April 25, 2008

Re: Status of Improvement Permit Application #08-5-19838
Persimmon Hill Lt 67

Joe West, R. S.
Environmental Health Specialist
Harnett County Department of Public Health

DB BUILDERS, LLC.
THE CLAREDON WITH SUNROOM
LOT # 67 PERSIMMON HILL
SCALE: 1"=40'

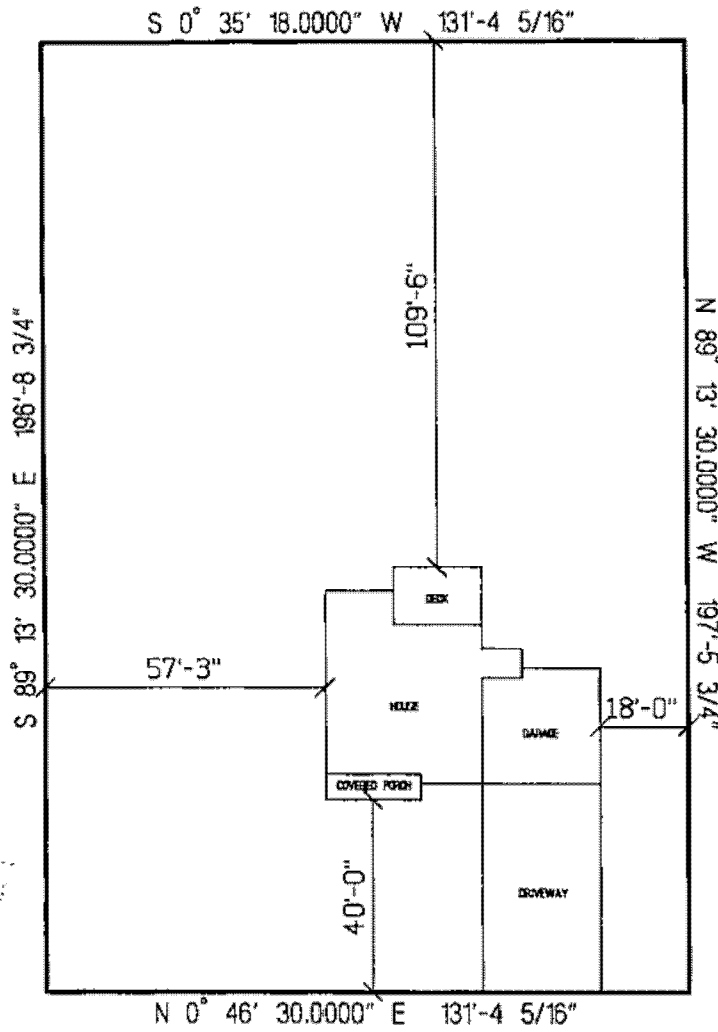
- 1. Property lines/corners not marked or labeled
- 2. House corners not marked or labeled
- 3. Directions not clear to property
- 4. Property needs brush or vegetation removed
- 5. Backhoe pits required
- 6. **Other – Please move house and drive as shown on attached sheet. Submit new plot plan to Central Permitting.**
